Australian Turf Club and Sydney's Light Rail project: Urban Impact Summary document- 18.12.2013

Sydney's Lightrail: Impacts Summary Sheet

CBD & SOUTH EAST LIGHT RAIL PROJECT

TECHNICAL REVIEW *(DECEMBER 2013)*

Figure 7-18: Royal Randwick Racecourse Precinct Access Plan

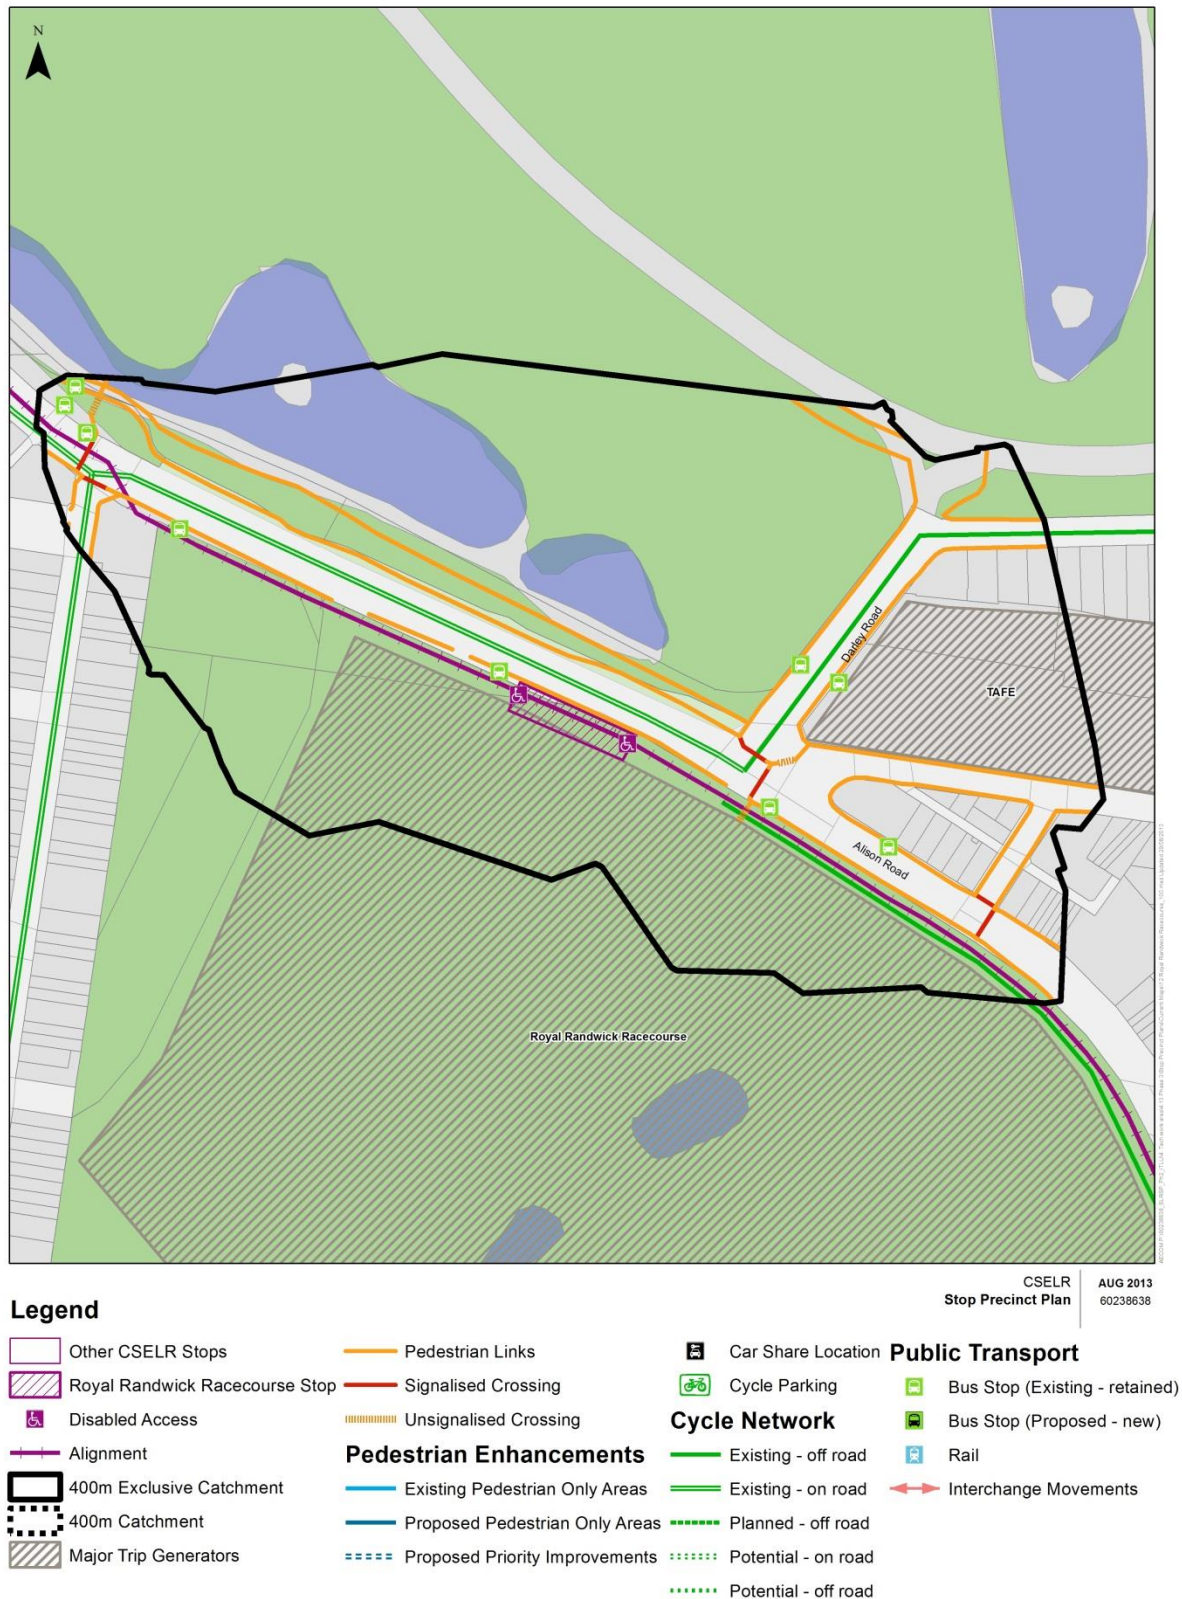
Buses required to stop in the traffic/bus lane – a lay-by for stopping buses required
Minimum pedestrian layover path on footpath
Combining bicycle path is dangerous

Heavy vehicle access to the in-field (currently through Gate 1 and Busway) would be severed by the current station layout/design.
No heavy vehicle access to spectator precinct considered.

Level change issue between the platform level and the existing RRR entry concourse not resolved.
Necessitates demolition of SWAB building, replacement of which is not considered.
No Assessment provided on impact to ticket and transitive buildings.
No defined assessment on pedestrian safety during major events.
No landscape plan provided.

Pedestrians are required to cross the tracks to connect with the footpath on the south of the station to a footpath on the north located between the tracks and the road. It is potentially a safety risk and forces passers-by to carry out conflicting pedestrian movements with event patrons. Safety with pedestrians being pushed onto Alison and back onto rail lines

Island platform arrangement requires all passengers (east and west) to cross the lines. Side platforms would require only one direction to cross the lines.
